Application Ref:	3/2025/0724			 Ribble Valley Borough Council www.ribblevalley.gov.uk				
Date Inspected:	3/10/25	Site Notice:	3/10/25					
Officer:	BT							
DELEGATED ITEM FILE REPORT:					APPROVAL

Development Description:	Erection of three-storey dwellinghouse with attached two-storey coach house adapted from existing structure. Planning permission previously granted (3/2024/0248) for similar sized house, existing house already demolished, and foundations for the accepted proposal have already been built.
Site Address/Location:	Hawthorn Bungalow, Rimington Lane, Rimington, BB7 4DP.

Title:
TREE IMPACT & PROTECTION PLAN
In Relation to Proposed Construction of Detached Residential Property

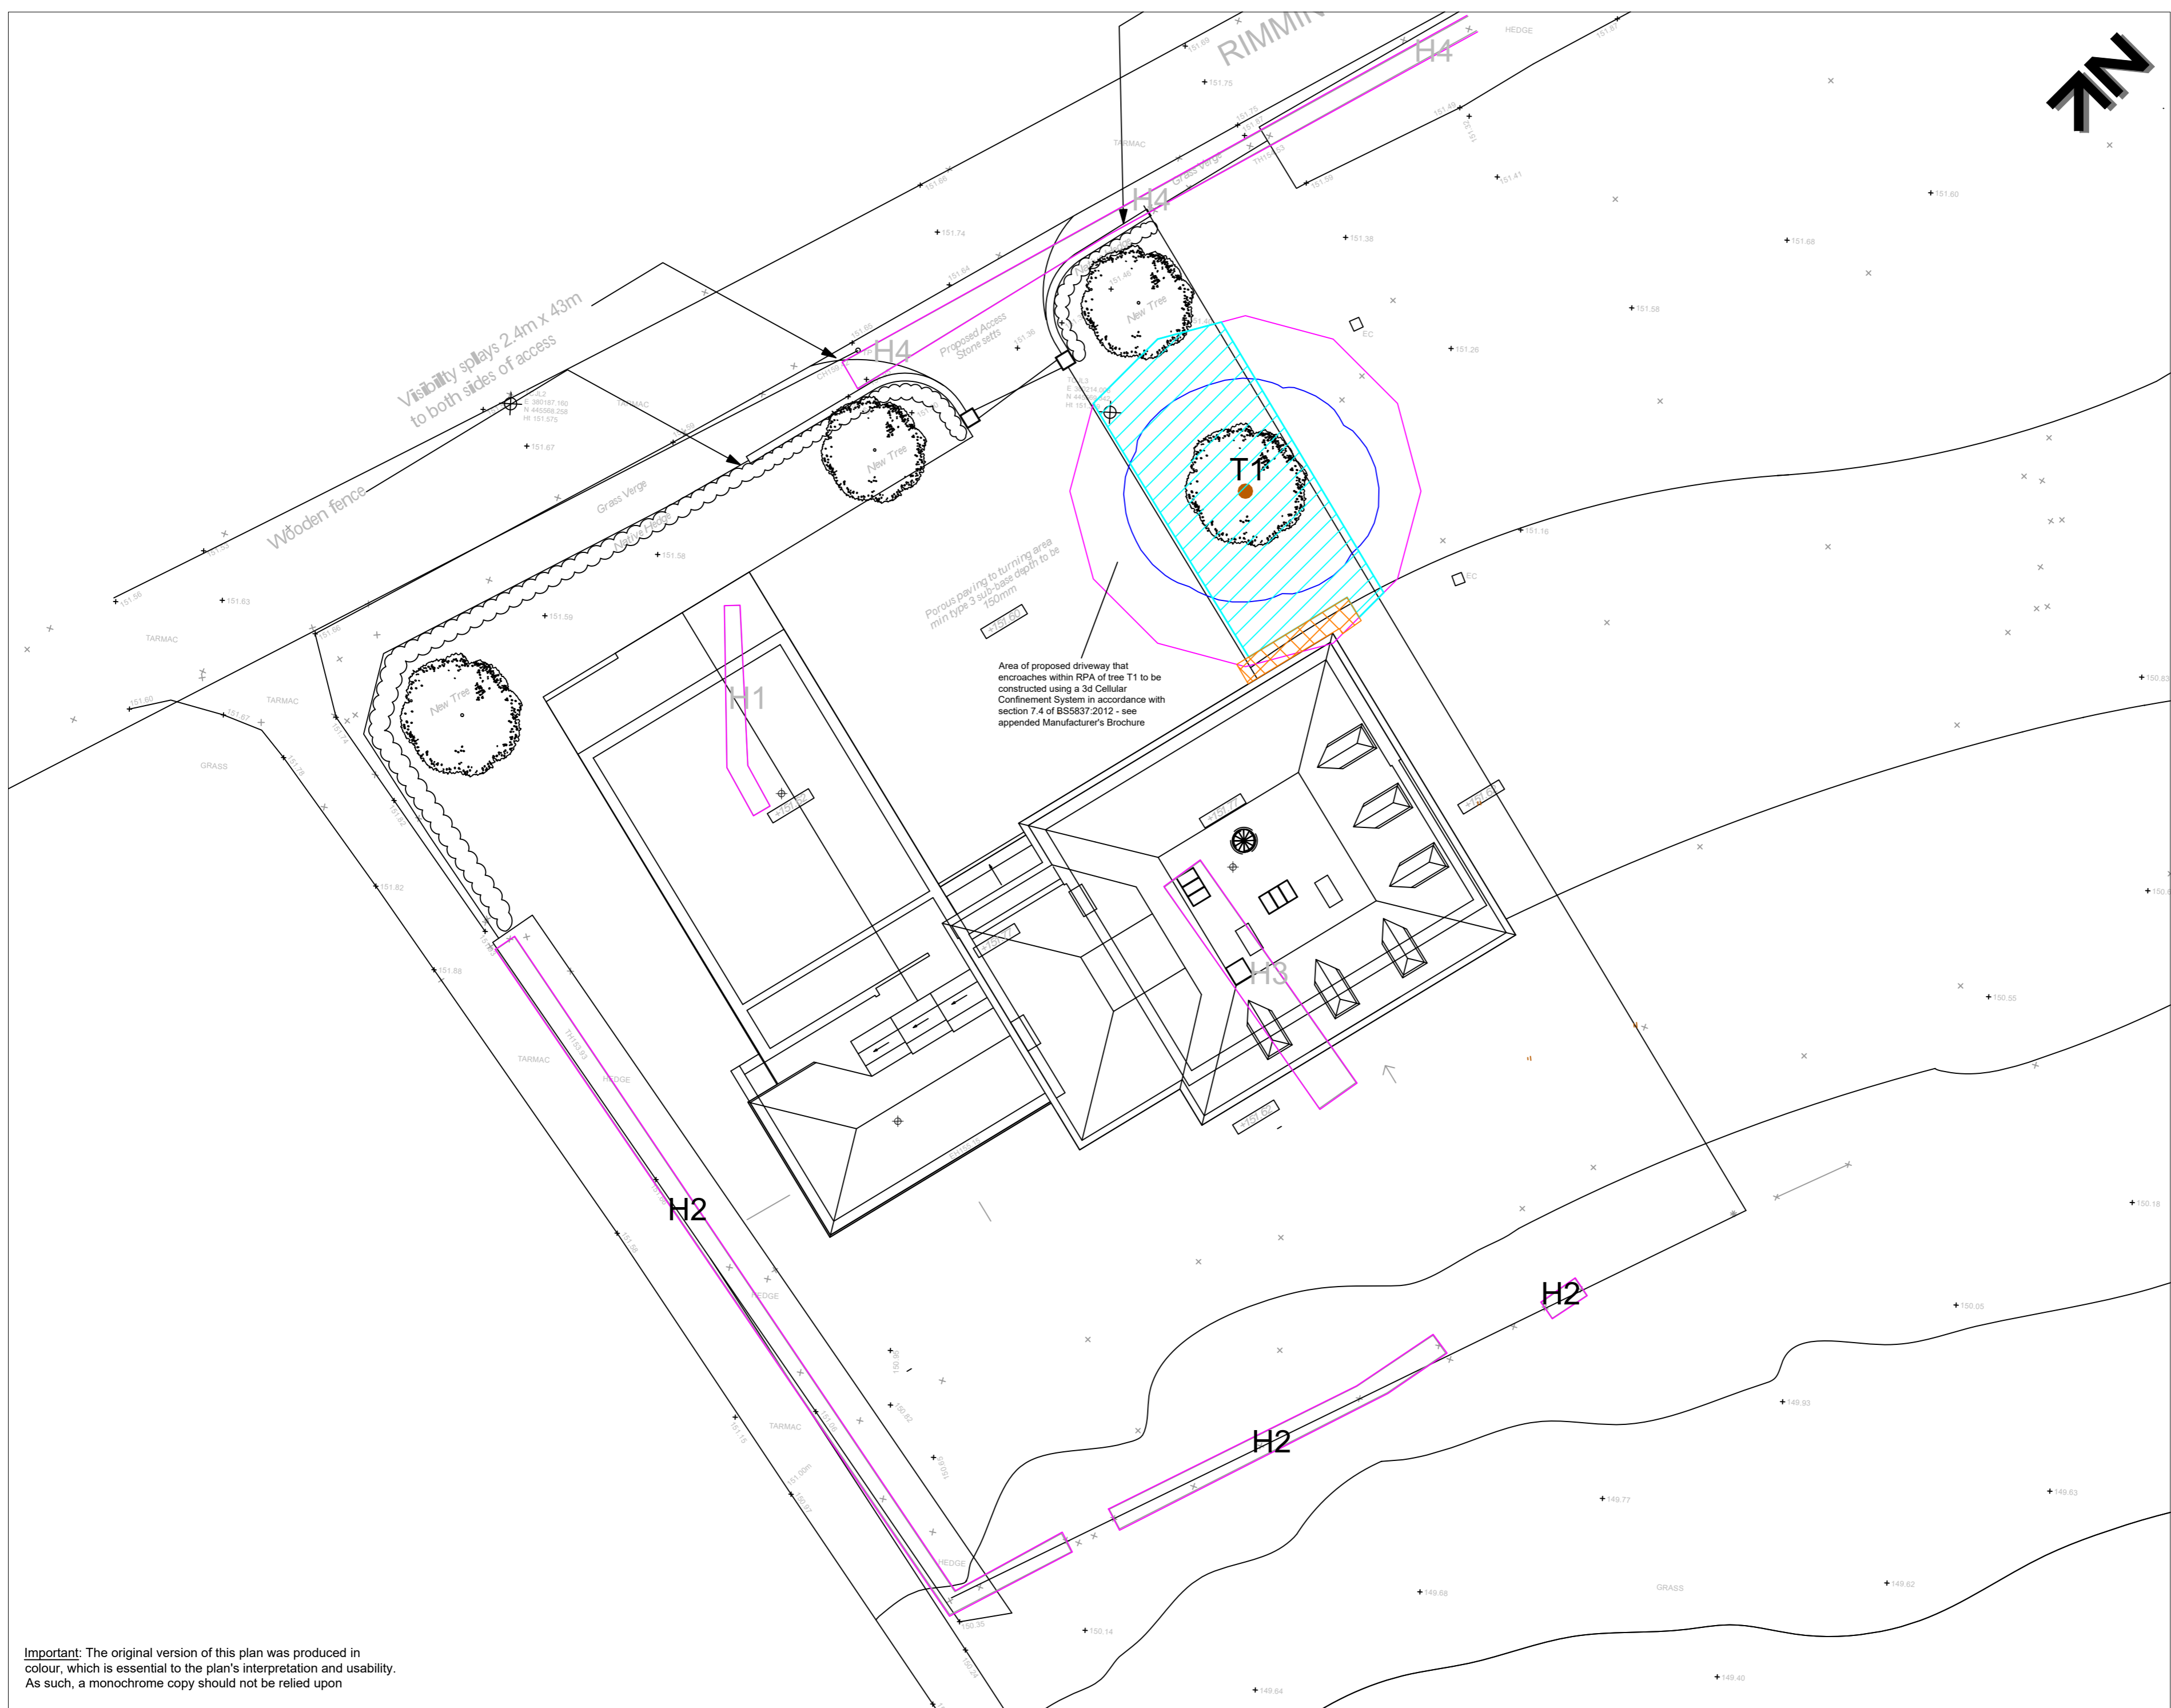
Prior to the application being registered the Council was informed by the applicant's agent that the site's construction access had been installed within the root protection area of T1, with an insufficient protective fencing zone having also been installed around the affected tree. Following this admission, an addendum to the Arboricultural Impact Assessment submitted under previous application 3/2023/0660 (which has also been submitted under this application) was provided as part of the application's validation process which states that the compacted gravel from within the root protection area of T1 is to be removed and with the correct tree protection fencing configuration to also be installed as shown on the Tree Impact & Protection Plan provided in support of the addendum to the original Arboricultural Impact Assessment. Removal of the compacted gravel and installation of the specified tree protection fencing would sufficiently safeguard the affected tree and is therefore considered to be acceptable.

An Arboricultural Impact Assessment has been submitted in support of the application which indicates the removal of hedges however these are low value hedges and their loss would be mitigated through proposed native hedgerow planting therefore their removal is considered to be acceptable. The relocated driveway access proposed for the site would encroach into the root protection area (RPA) of a silver birch tree (identified as T1 in the submitted AIA) however the RPA of the affected tree is to be safeguarded by way of a construction

exclusion zone (CEZ) with a Cellular Confinement System to be utilised to construct the proposed driveway in order to avoid compromising the RPA of the affected tree. The submitted Arboricultural Impact Assessment has previously been reviewed by the Council's Countryside Officer who raised no issues with the works and methodologies proposed. Consequently, the proposed development raises no concerns with regards to impacts upon trees or hedges.
